An
Bord
Pleanála

Inspector's Report

ABP-312543-22

Development	Open a Quarry
Location	Garrans, Stradbally, Co. Laois.
Planning Authority	Laois County Council
Planning Authority Reg. Ref.	210605
Applicant	Pat Booth
Type of Application	Permission
Planning Authority Decision	Refuse Permission
Type of Appeal	First Party
Appellant	Pat Booth
Observers	Adrian Guinan & Mary Jo Costello Sean & Anne Hardy Joe Costello John Gormley John George Anthony Coss Peter & Ann Walsh Kemmis David Little Louise & Paul Conroy
Date of Site Inspection	12 th July 2023
Inspector	Dolores McCague

Figure 2: Site Layout Plan (Ref: For full details, refer to planning drawings)

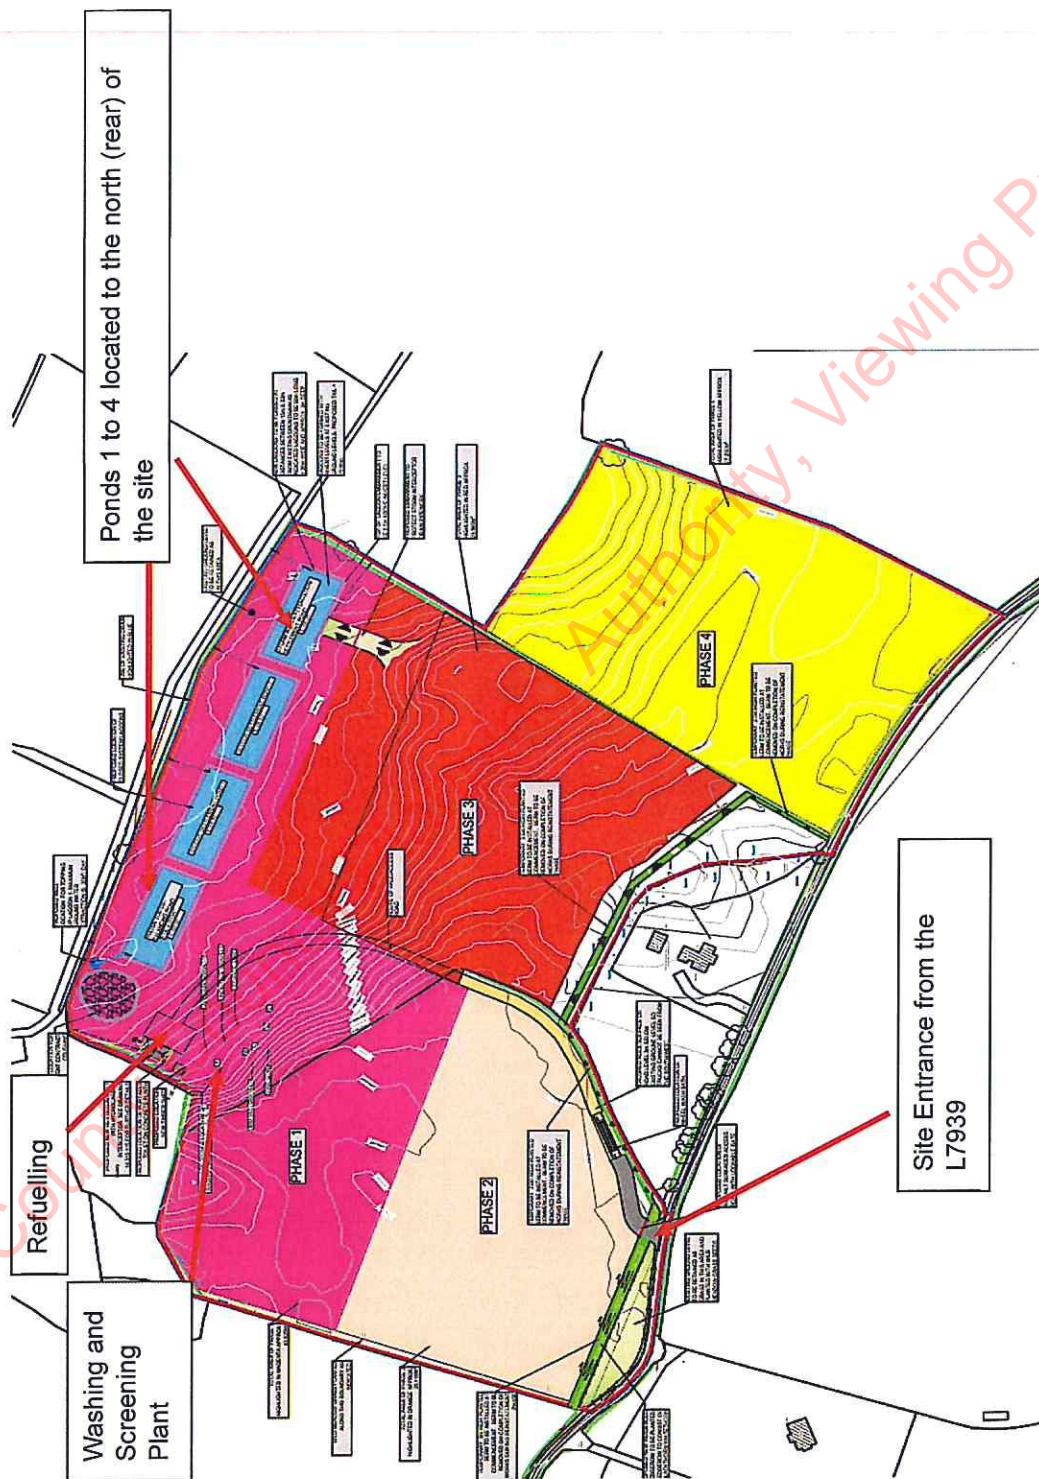
- 1) Sections submitted are not sufficiently clear, revised sections including the proposed safety berm, existing/proposed boundary treatment, fencing, existing neighbouring dwellings, existing drain, proposed buildings, machinery, balancing ponds. The revised sections shall also demonstrate the relationship between the proposed berms and the dwelling house that is closest to the application site.

- 2) The drain on the northern side of the site is not clearly shown on the submitted planning application drawings – full set of revised plans required. A 60m wide buffer is proposed, show its full extent, and the extent of all other buffer zones (badger setts, tree root zone protection etc); show proposed locations of stockpiles.

- 23) Air Quality and Climate – methodology for assessment unclear; EIAR has not distinguished between different weather events.
- 24) Concerns regarding the location of the wheel wash and the internal access road and proximity to residential property; submit proposals.

- Updated mitigation – there is a badger sett (sett ‘X1’) located within the phase 4 area. A 50m buffer zone for extraction activities will be retained around this and all setts. Extraction activities will not commence in this area of the site for a number of years. If upon review, this sett is still active, badgers will be excluded from the sett and any other setts that may be identified and considered vulnerable. Other setts (sett ‘X4’, ‘X5’) close to the site may also be indirectly affected by the ground disturbance from the quarrying activities – a 50m buffer zone for extraction activities

- Relocation of the intermittent crushing stockpile, washing and screening plant that includes extraction, washing, sizing, screening and stockpiling; from the north western corner, to the north central area of the site.

- Relocation of the new shed, refuelling bay and hydrocarbon interceptors from the north western corner to the north eastern boundary.
- Relocation of the site wheel wash bath, and rerouting and widening, at a reduced ground level, of the Haul Access Road, along the perimeter of the residential land, and additional vegetation berms to be planted on both sides of the tarmacked road and the road widened locally for the operation phases.

Figure 7: Proposed lay-bys on the local road L7939 (extracted from planning drawings)

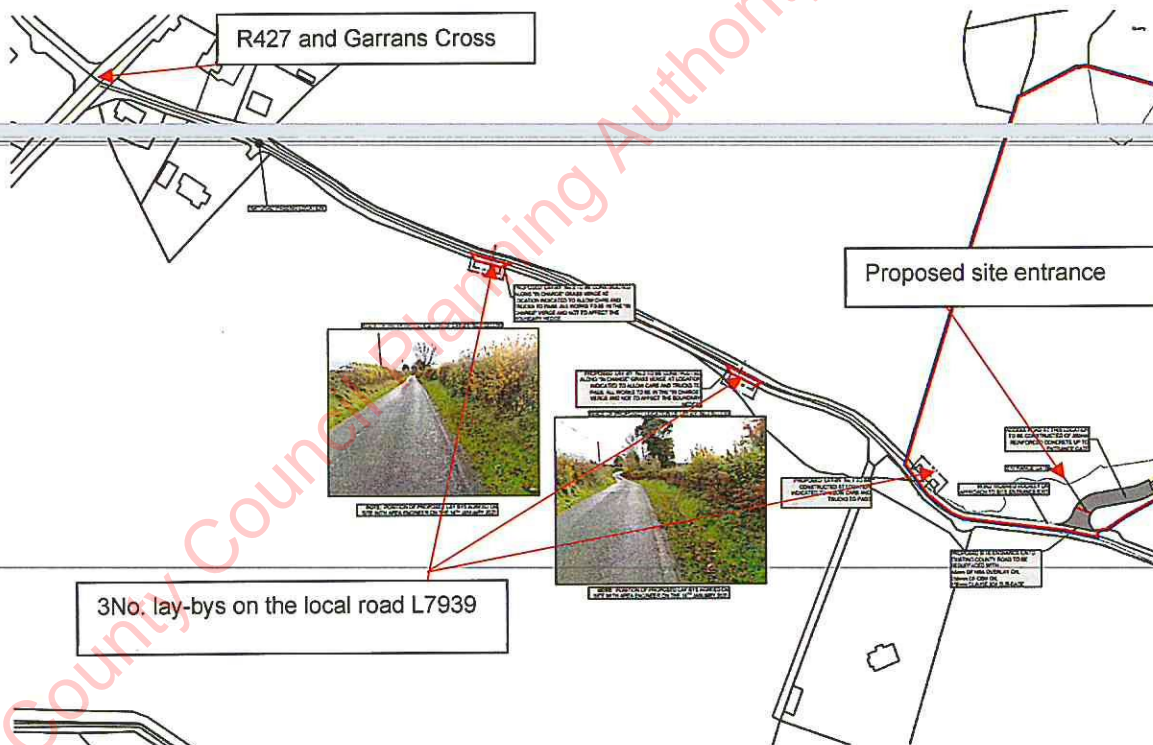
- Observer – inaccurate maps – no permission for two laybys on our land.
- Noise – impact on nearby houses to be clarified.
- Ballykilcavan Bridge 630m to the east, is a protected structure (ref RPH 599). The local road, prior to its junction with the R428, crosses that bridge. It is stated that access will be via the R427.

- 17) Re. passing bays: photographs, plans and letters of consent.
- 18) Noise and vibration – how was vibration scoped out.
- 19) HSE concerns in relation to the EIAR - assessment of noise impact is not adequate – weekends and weekdays are not distinguished; tonal and impulsive noise is not adequately considered; and the assessment did not discuss the context of the predicted noise per BS4142.

Figure 9: Landscape Plan for the restoration phase

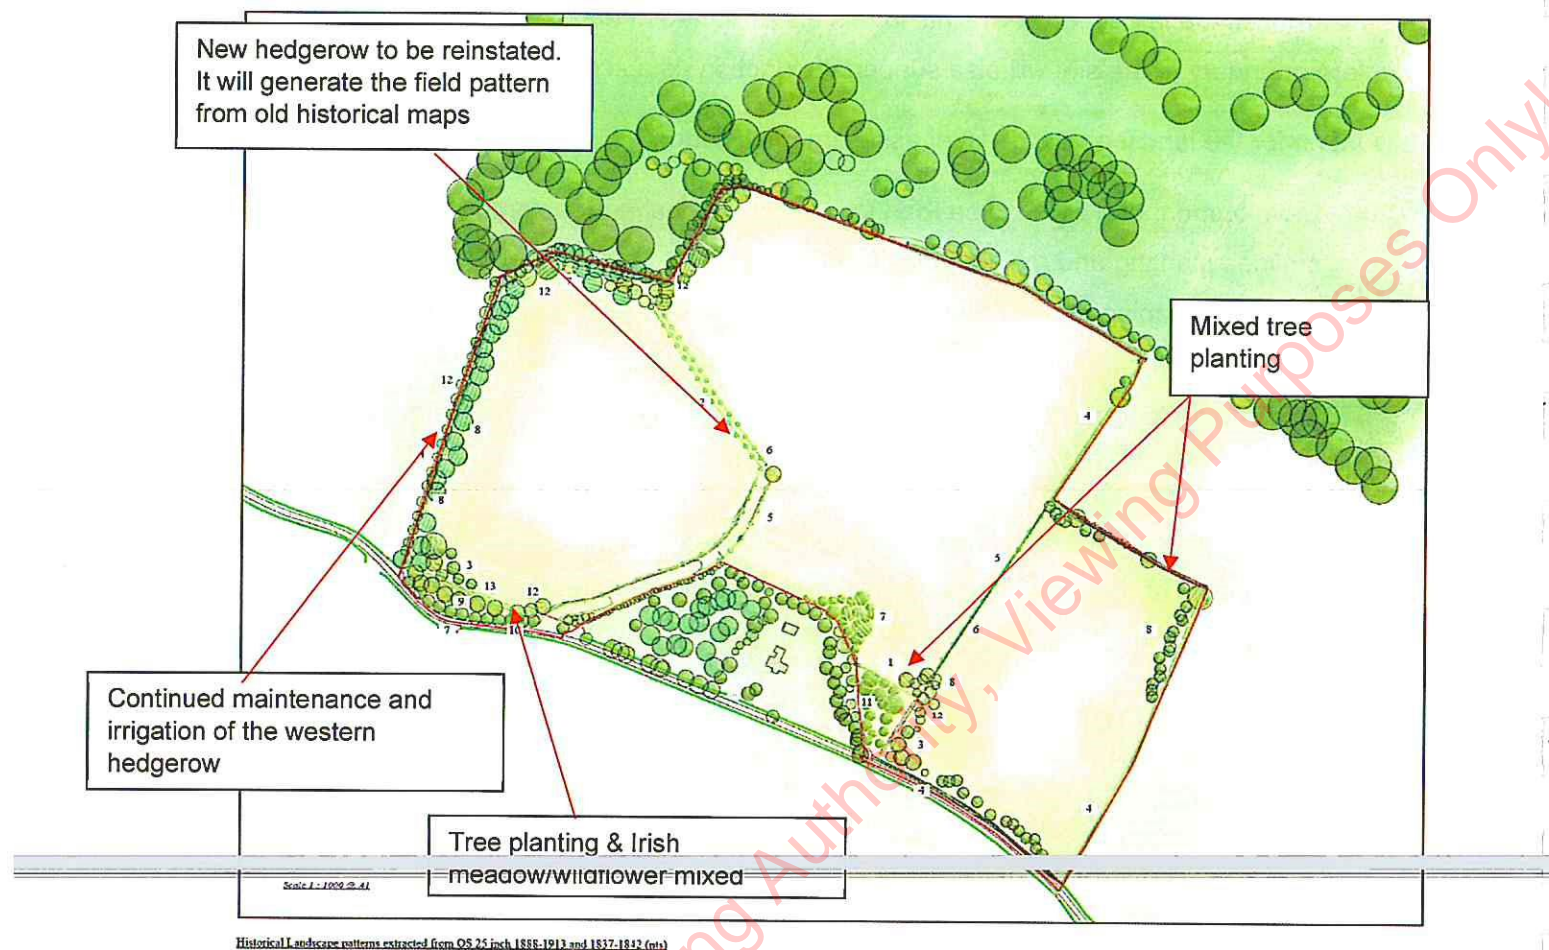
- 25) Landscape & Visual – restoration plan – to be planted with native woodland.
- 26) Biodiversity – Bat survey. Bird survey.
- 27) Drain habitat, not identified on figure 11.8; revise.

- 28) Landscape plans are small and difficult to read. It is not clear which trees will be removed and which will be protected. Details required: listed a) to e).

3.7.2. Re. DAU submission – a revised landscape restoration masterplan has been provided within Appendix B. A large part of the overall proposal is to manage fields as 'traditional hay meadow to be seeded from locally sourced seed and appropriate for grazing'. The Department have advised that managing land as traditional hay meadow is complex and that there is insufficient detail in the Landscape Plan to ensure that this management option is successful and provides optimum habitat for biodiversity, particularly the population of Yellowhammer noted in the Bird Survey in Appendix 1, a red listed species within the Birds of Conservation Concern in Ireland assessment. Therefore the Department have submitted that a Traditional Hay Meadow Management Plan be submitted by way of clarification of FI.
